Application No: FG/101/25/PL
Site Address: 4 South Drive Ferring BN12 5QS
Description of works: Erection of replacement dwelling together with reprofiling of the site and installation of new boundary to front of site. This application is in CIL Zone 4 and is CIL Liable as a new dwelling.

Thank you for your internet representation made on 10th September 2025 which has been recorded as an objection with the comments as follows:

PROPOSED REAR AND SIDE
ELEVATIONS

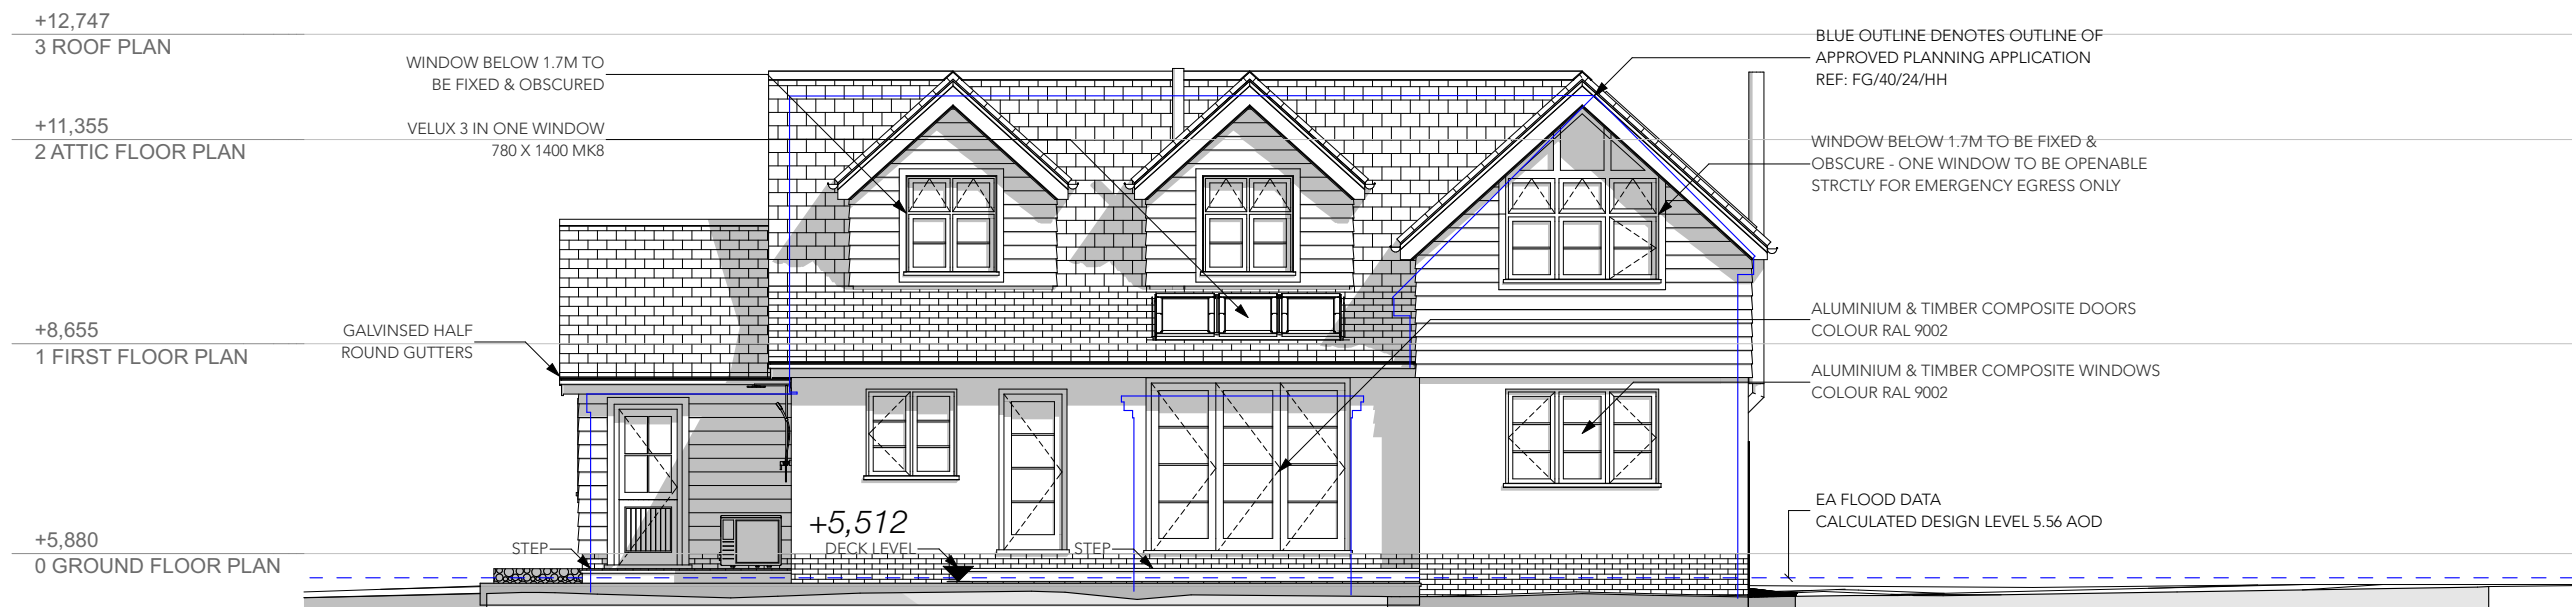
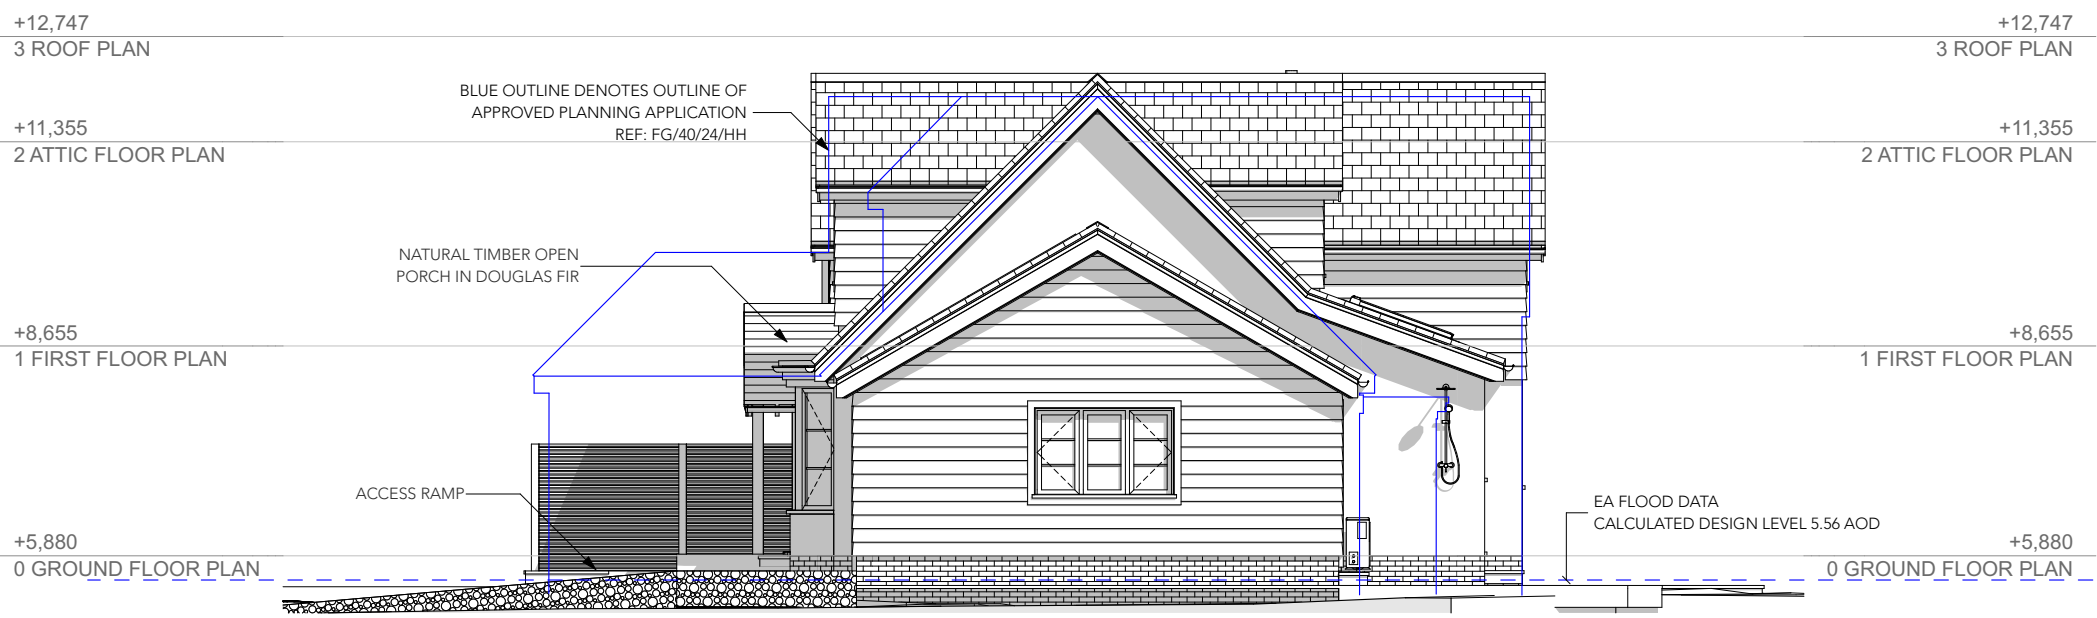
I write to object to the above application for a replacement dwelling. The rear of the proposed development will directly overlook my property and garden

Even with partial obscured glass the rear first floor windows will directly overlook much of my garden and my kitchen and lounge. I consider this a threat to my residential amenity and privacy, contrary to Arun planning policy D DM1.
